Recommendation Report for Planning Permission for Works or Extension to a Dwelling

REF NO: AW/170/20/HH

LOCATION: 116 Nyetimber Lane
 Aldwick
 PO21 3HL

PROPOSAL: Dropped kerb.

116, Nyetimber Lane, Aldwick, West Sussex, PO21 3HL

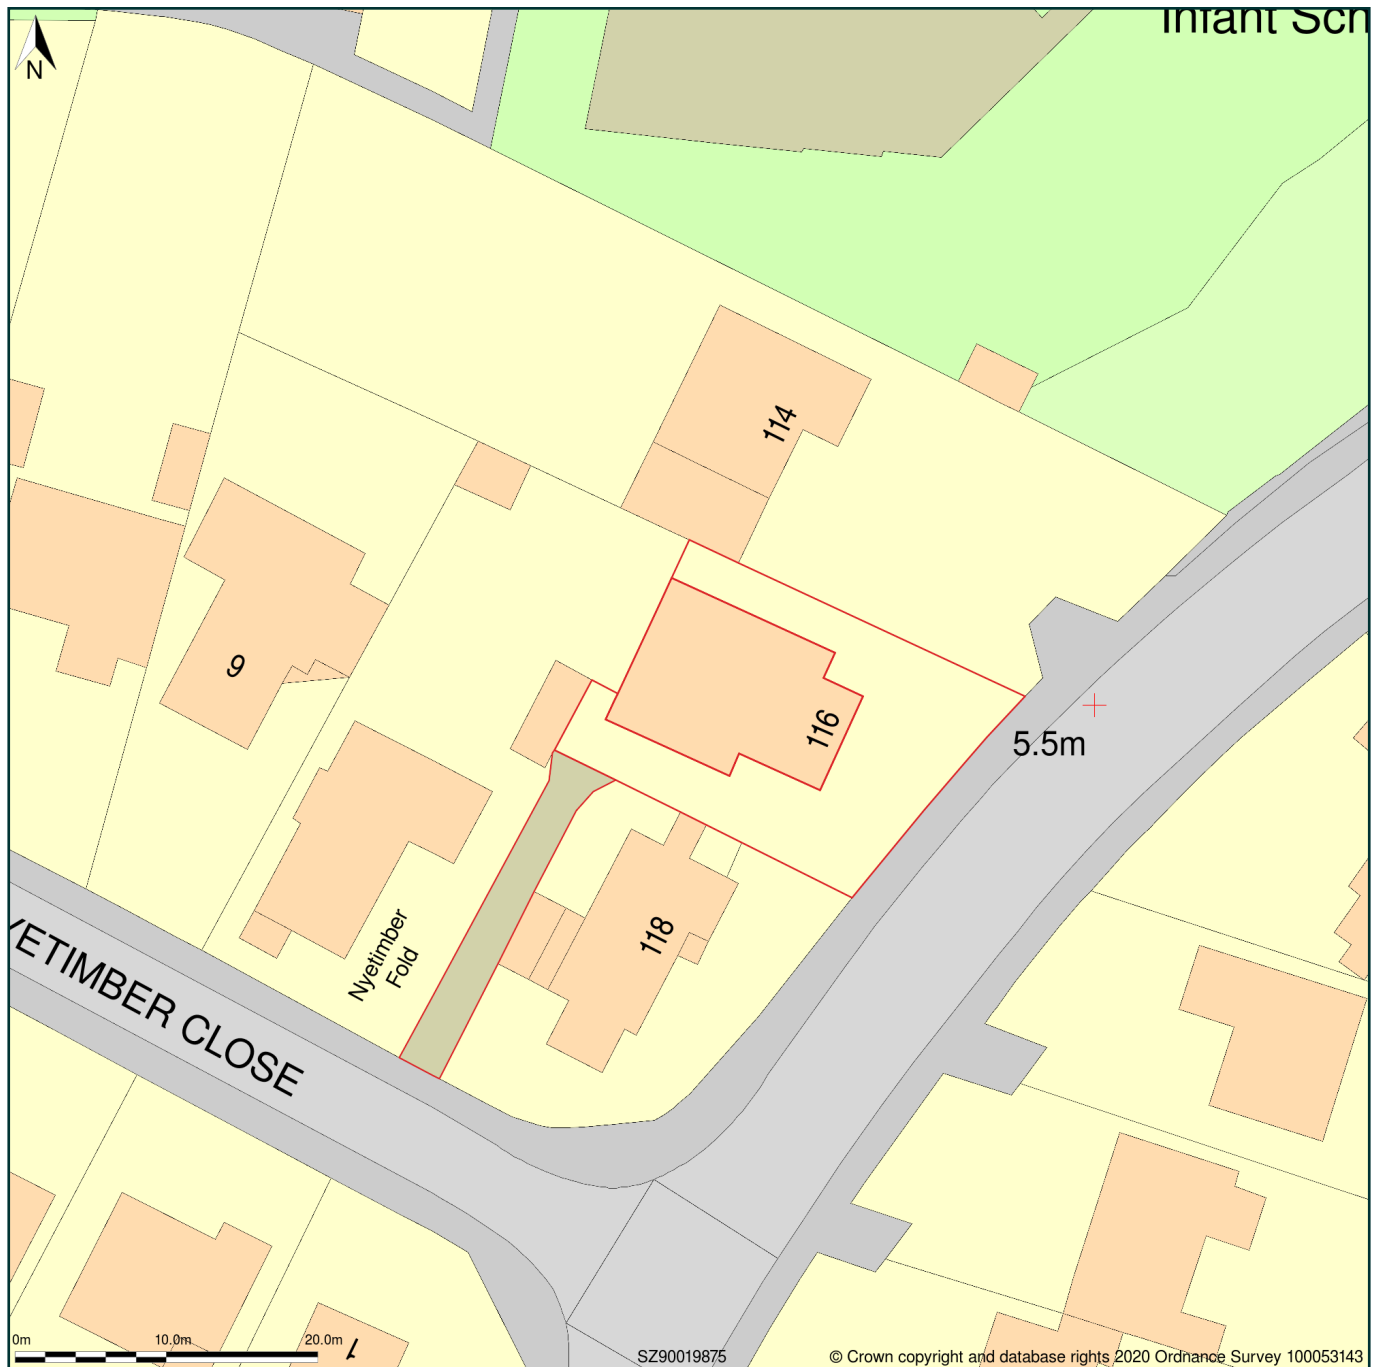
The applicant proposes to implement a 5.5m VCO at this location. This conforms to the maximum VCO guidance of 6.4m in WSCC guidance. From an inspection of WSCC and local mapping and the submitted plans demonstrating visibility of 2.4 x 43 metres in both directions, visibility along Nyetimber Lane is enough with excess of 2.4m by 43m available from the centre of the access point, within maintainable highway land. Manual for Streets sets out that 43m is suitable stopping sight distance (SSD) for vehicle speeds of 30 mph and therefore the LHA would not anticipate that the proposal would generate a highways safety concern at the proposed access.

- 3 The use of the access shall not commence until visibility splays of 2.4m by 43 m in both directions have been provided at the proposed site vehicular access onto Nyetimber Lane in accordance with the approved planning drawings. Once provided the splays shall thereafter be maintained and kept free of all obstructions over a height of 0.6m above adjoining
